# v1\_Landscape Plan drawings.pdf Markup Summary

COM2346

**Subject:** Planner  
**Page Label:** [19] L7.0 LANDSCAPE PLAN  
**Date:** 1/24/2024 10:00:06 AM  
**Author:** ashmathy  
**Status:**  
**Color:** ■  
**Layer:**  
**Space:**

PROJECT NO. 196489000
SHEET L7.0

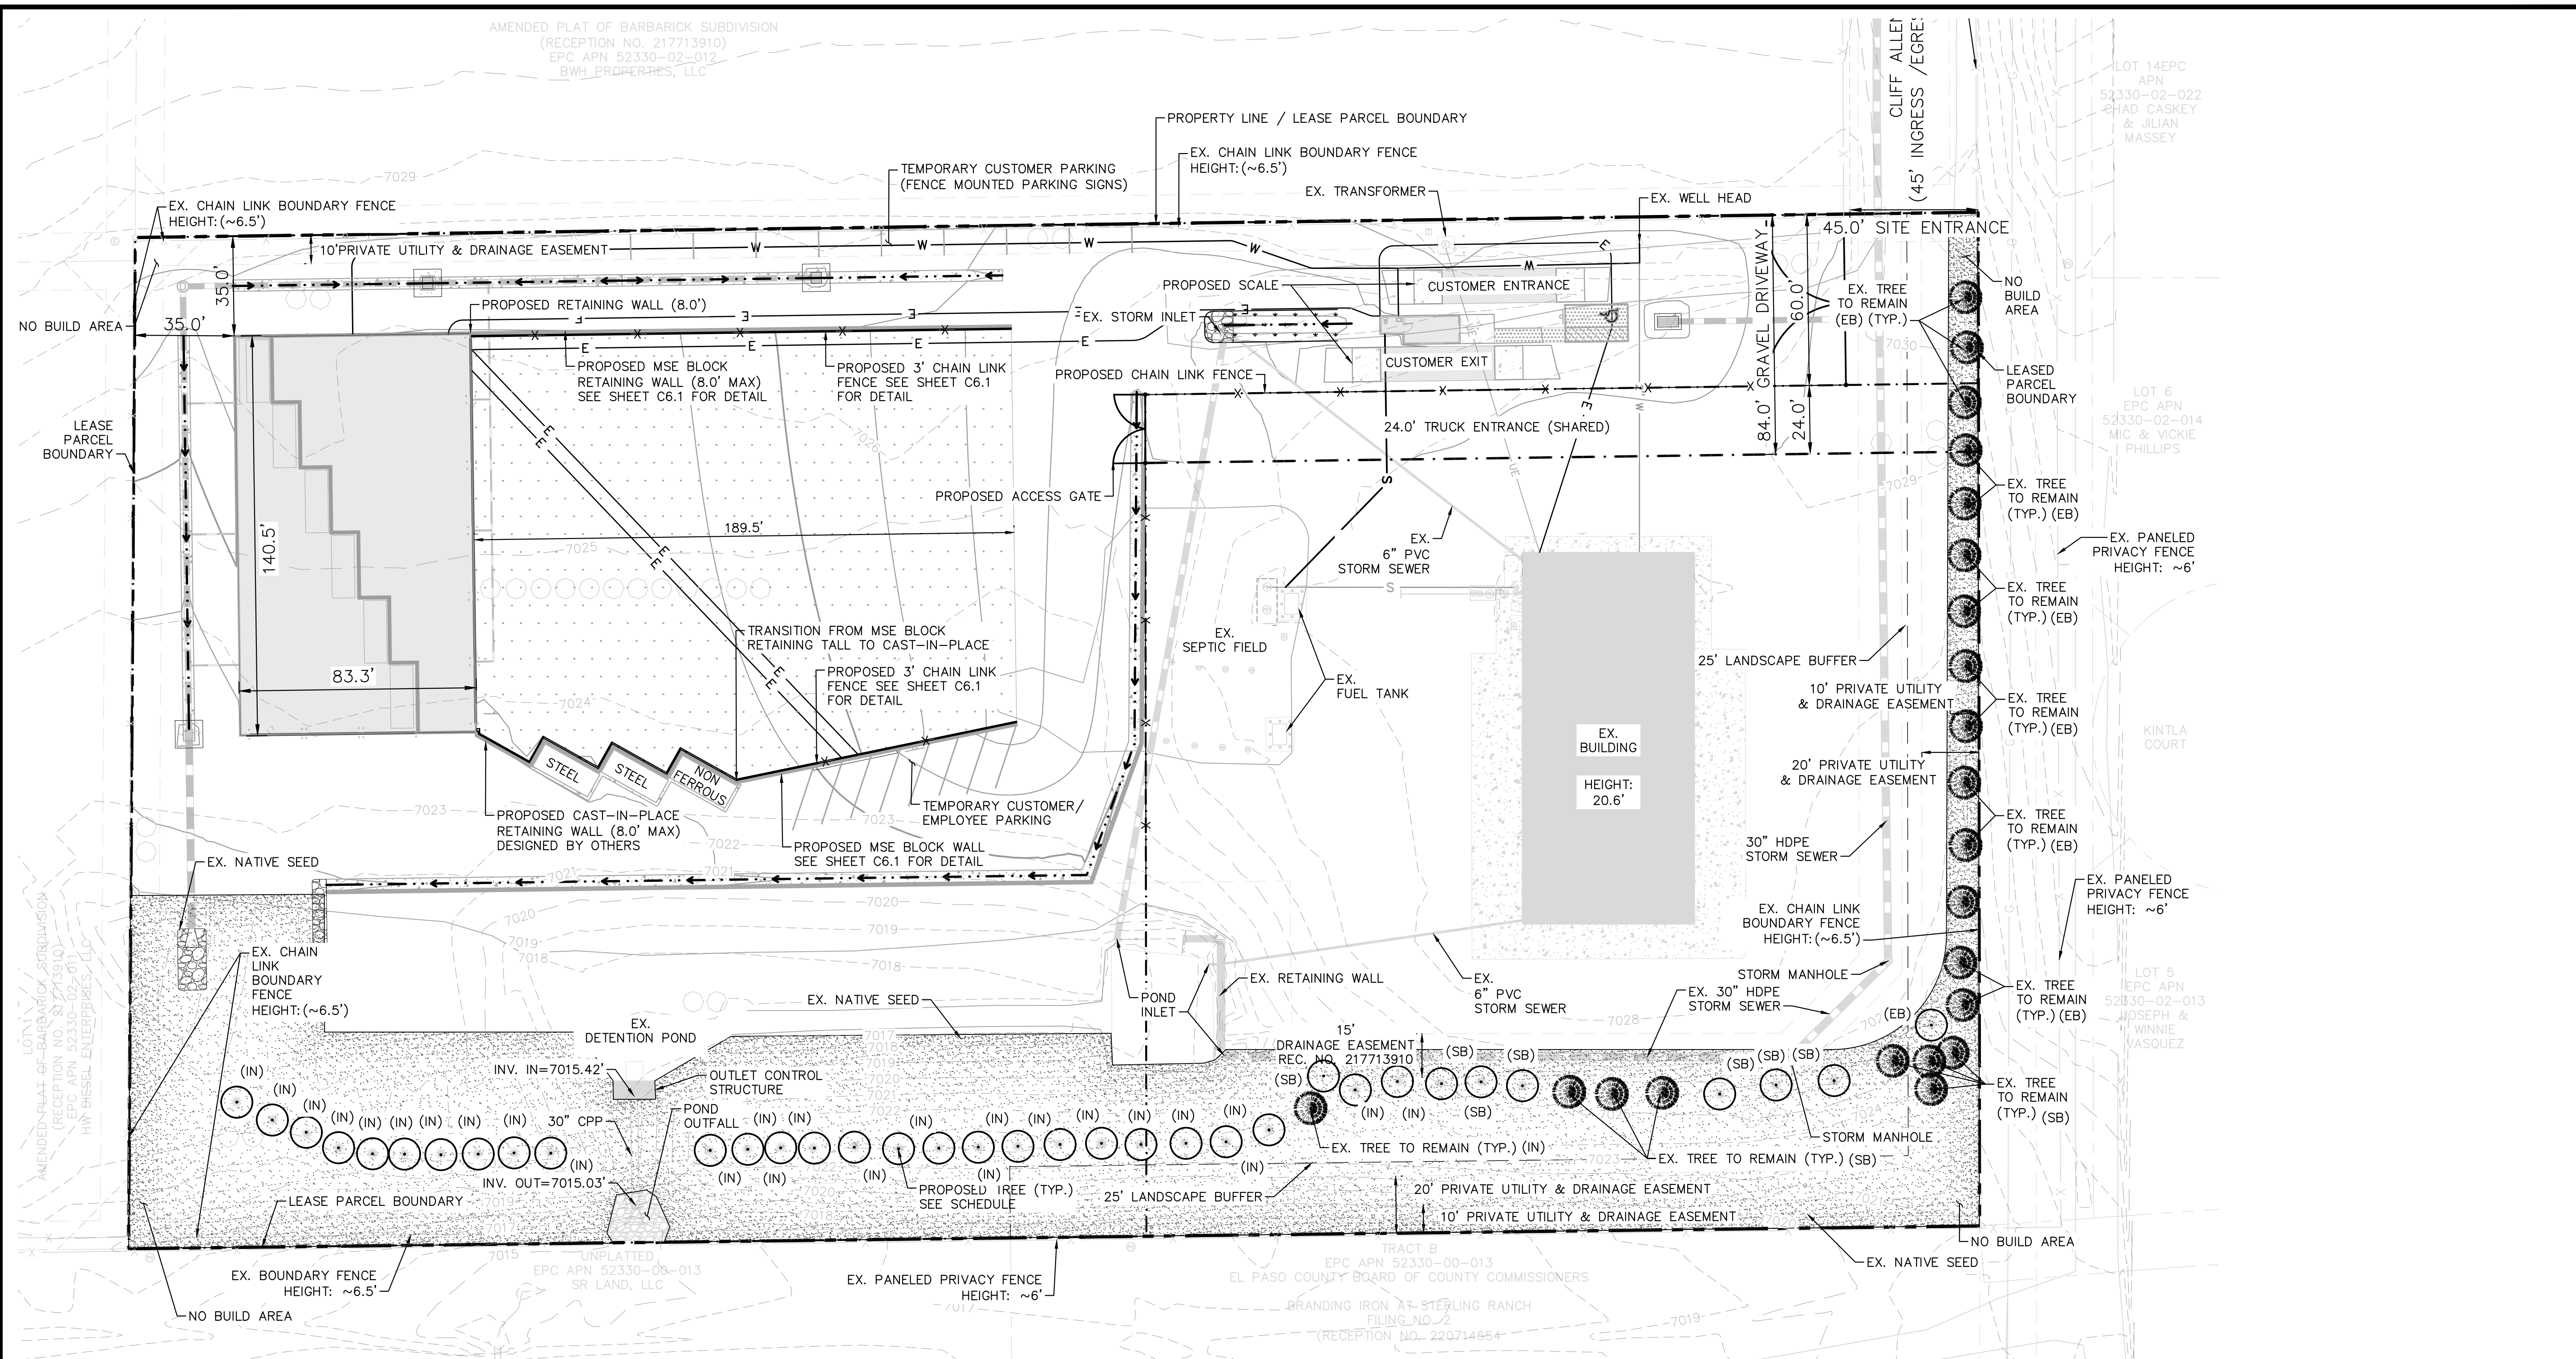
Please include:  
-a table depicting required vs provided (plant count/vegetation in sq ft)  
- site distance triangle
